Subject: R-6 Small Infill Design Review – 70 Anderson Street

Written by: Caitlin Cameron, Urban Designer

Date of Review: Friday, September 16, 2016

NORTH EAST ELEVATION VIEW - BUILDING B

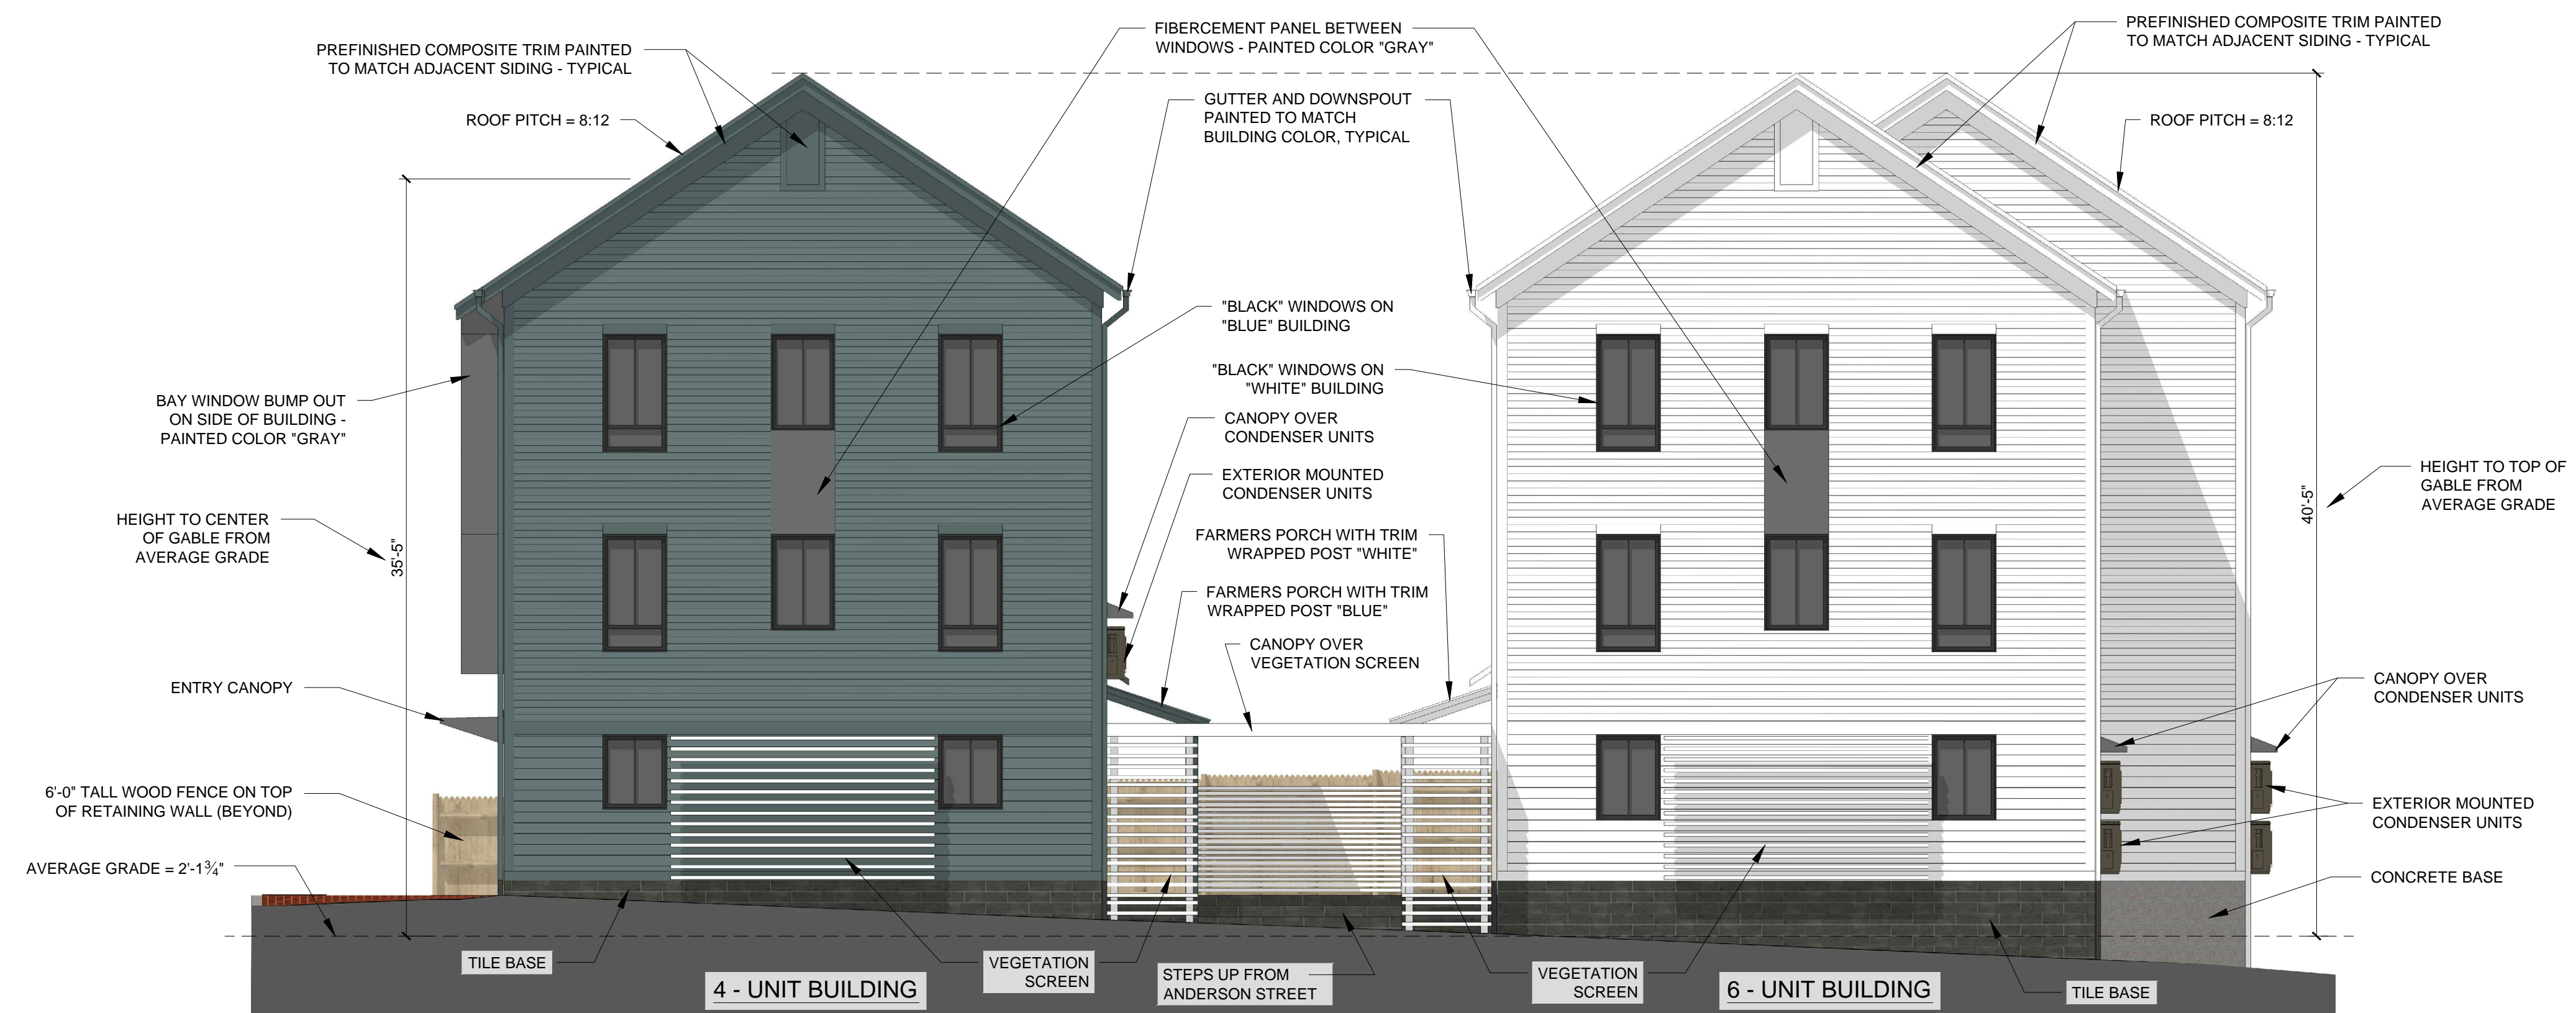
- *B-1 Massing:* The proposed mass is wider on the street than the typical building context but the use of row houses mitigates that massing.
- *B-2 Roof Forms:* **The gable roof was revised to have an 8:12 pitch and the trim details revised to create a more vertical proportion from the Anderson Street view.**
- *B-3 Main Roofs and Subsidiary Roofs:* Met – there is a clear main roof form.

- *B-4 Roof Pitch:* The standard requires gable roofs to have a slope between 7:12 and 12:12.
- *B-5 Façade Articulation:* The project revision employs two of the required articulation elements – covered entries and bays. **Bays were added to Lancaster Street to meet the standard. Though the standard is technically met, staff would prefer the bays appear on all four units facing the street to create a consistent rhythm and legibility of the row houses.**
- *B-6 Garages:* Not applicable.

- *C-1 Entrances:* The entry to each unit is well-emphasized with the canopy.
- *C-2 Visual Privacy:* **Visual privacy was addressed by shortening ground floor windows to be higher than 48” above adjoining sidewalk grade; the ground floor was raised and additional 12” to help create privacy for ground-floor living spaces.**
- *C-3 Transition Spaces:* The project uses a canopy at each entrance but very little transition space is provided.

- *D-1 Windows:* The majority of windows are rectangular and have vertical proportion; **window proportion was changed to better reflect the proportions found in context.**
- *D-2 Fenestration:* The project appears to meet the 12% fenestration requirement and appropriately scaled to the massing of the building.
- *D-3 Porches:* Not applicable

- *G-1 Materials:* The residential context is predominantly clapboards with occasional shingle or brick. **Project will use clapboard with panel at the bays and tile at the base.**
- *G-2 Material and Façade Design:* The materials are appropriately placed according to their nature.
- *G-3 Chimneys:* Not applicable.
- *G-4 Window Types:* Two window types.
- *G-5 Patios and Plazas:* Internal plaza space uses stone steps and a concrete brick paver with rain garden and planting areas.
